**EL PASO COUNTY PLANNING AND  
 COMMUNITY DEVELOPMENT  
 DEPARTMENT**

**GRADING AND EROSION CONTROL PLAN CHECKLIST**

GEC1

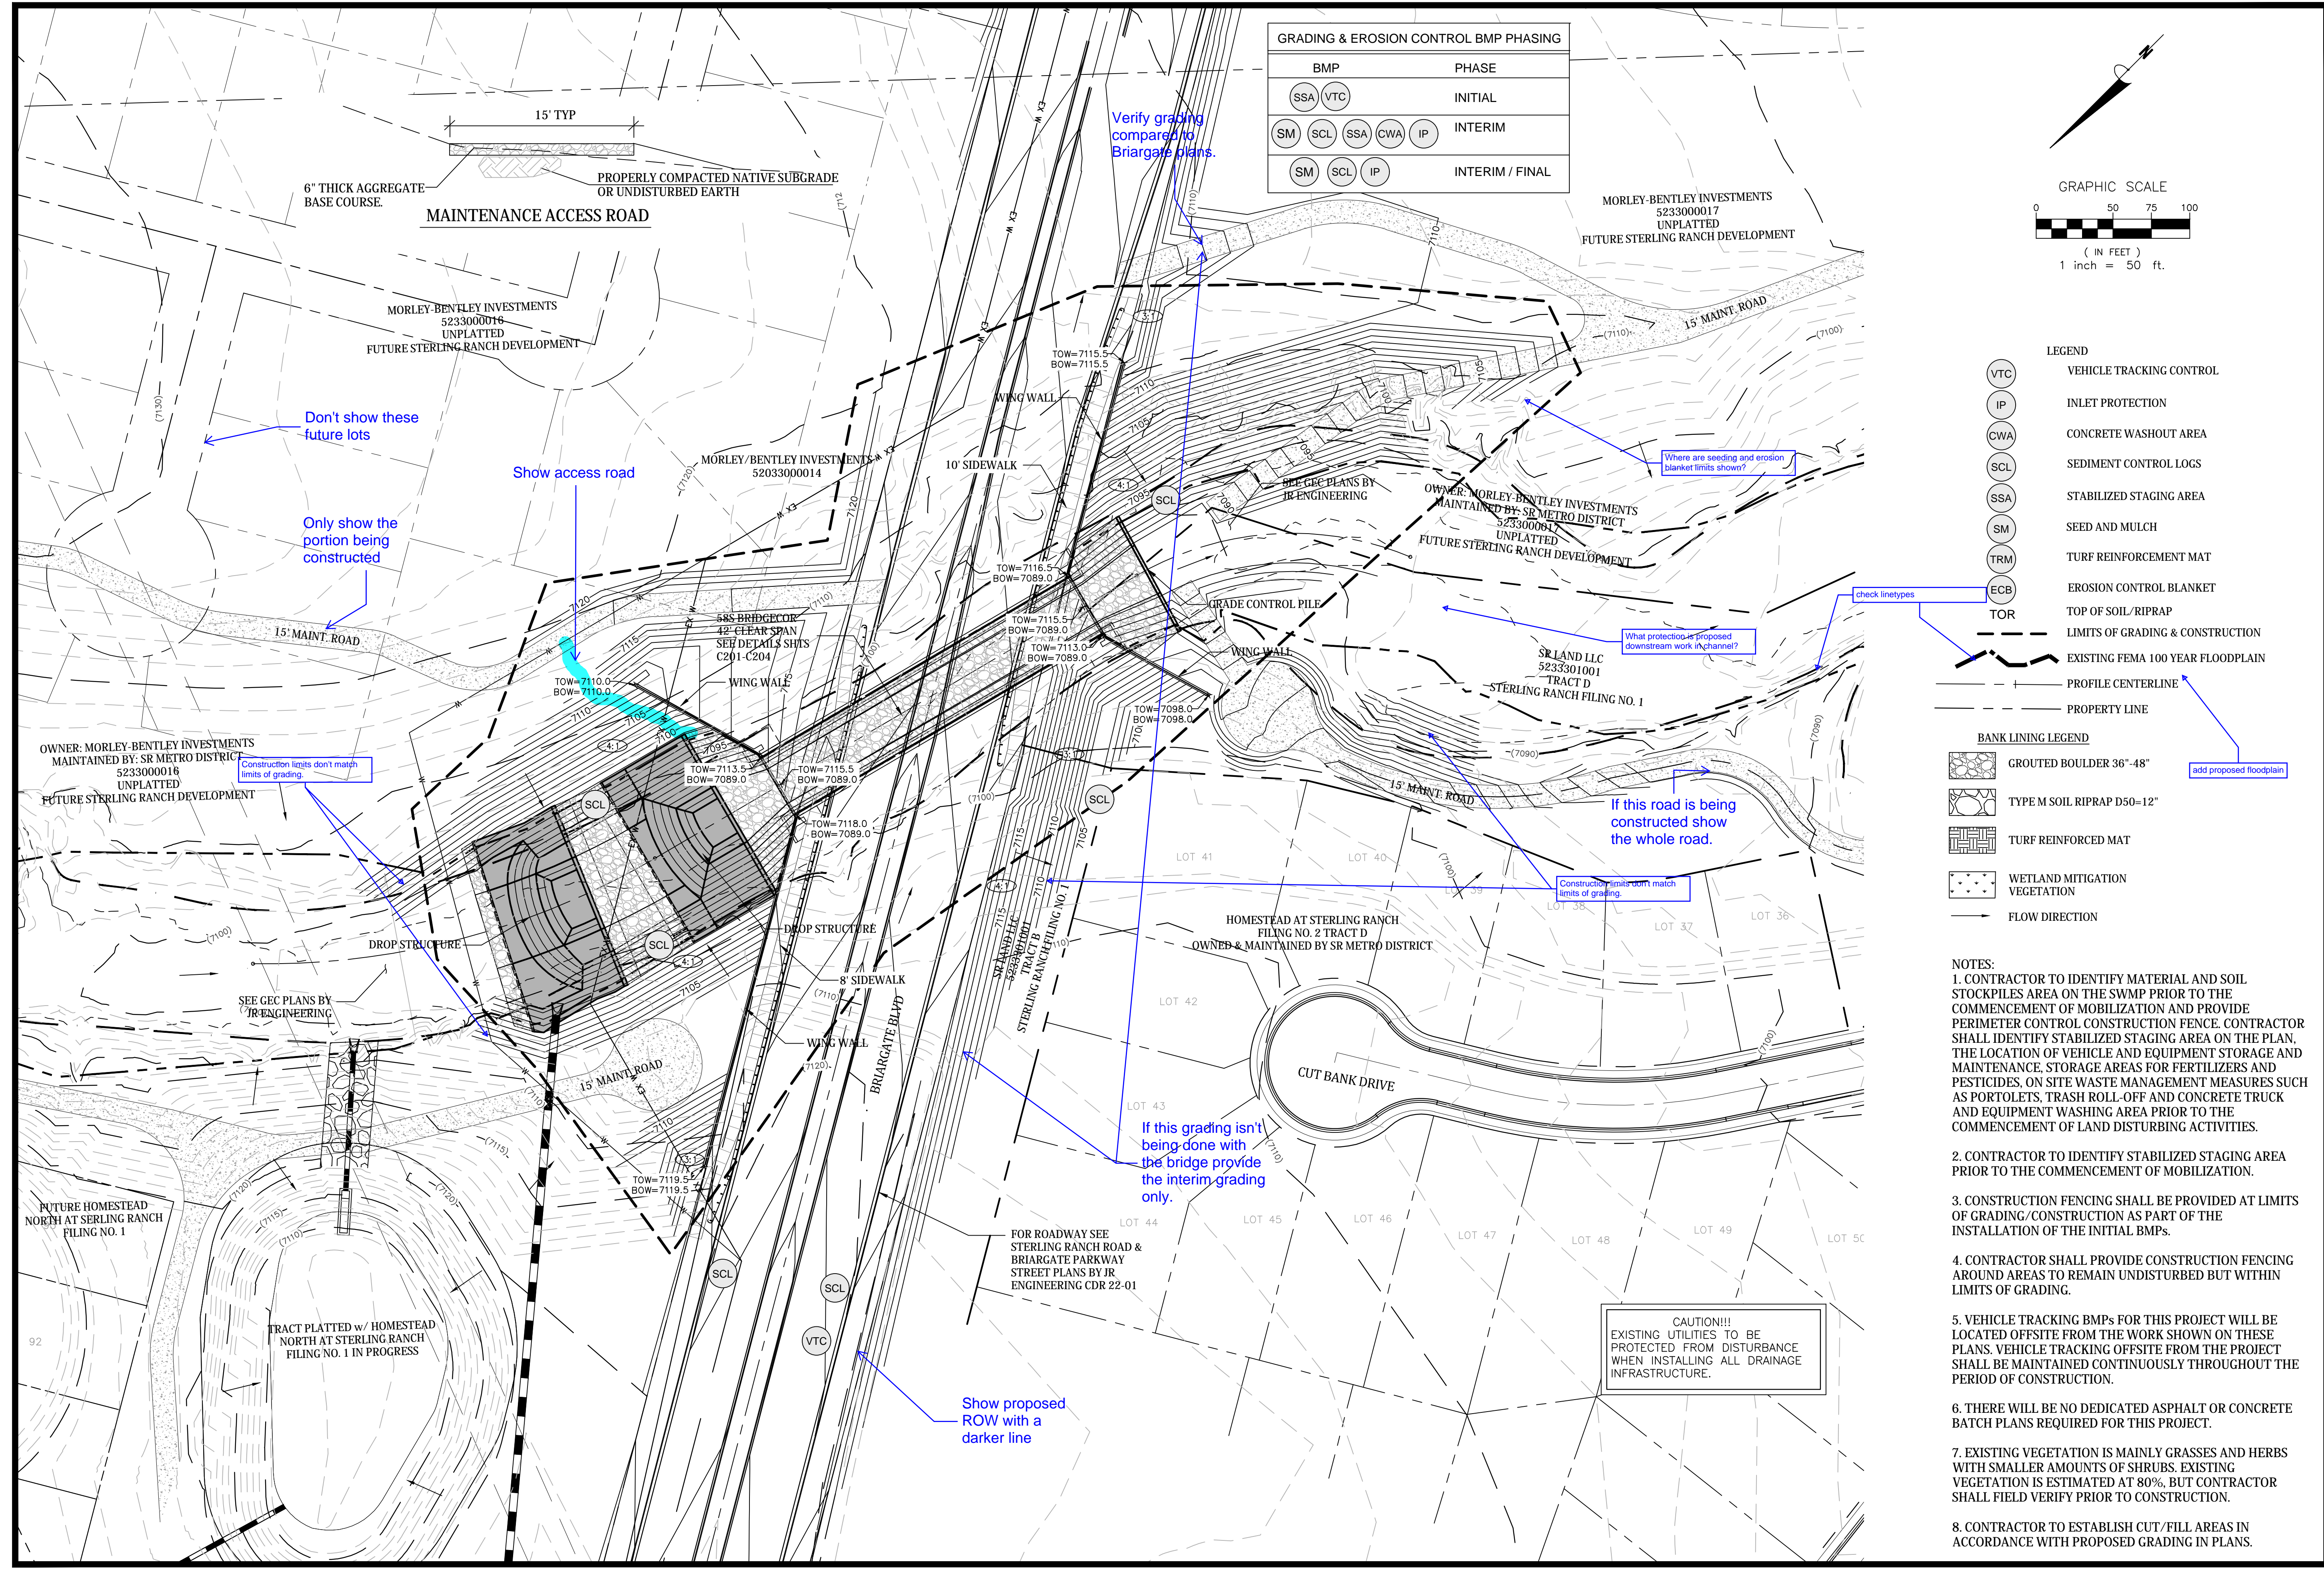
l	Existing and proposed contours 2 feet or less (except for hillside).	X	Y
m	Limits of disturbance delineating all anticipated areas of soil disturbance <span style="border: 1px solid black; padding: 2px;">see comment on sheet GEC1</span>		
n	Identify and protect areas outside of the construction site boundary with existing fencing, construction fencing or other methods as appropriate.	X	Y
o	Offsite grading clearly shown and called out.	X	Y
p	Areas of cut and fill identified.		N
q	Conclusions from soils/geotechnical report and geologic hazards report incorporated in grading design (slopes, embankments, materials, mitigation, etc.)	X	Y
r	Proposed slopes steeper than 3:1 with top and toe of slope delineated. Erosion control blanketing or other protective covering required.	X	Y
s	Stormwater flow direction arrows.	X	Y
t	Location of any dedicated asphalt / concrete batch plants.	X	N/A
u	Areas used for staging, storage of building materials, soils (stockpiles) or wastes. The use of construction office trailers requires PCD permitting.	X	Y
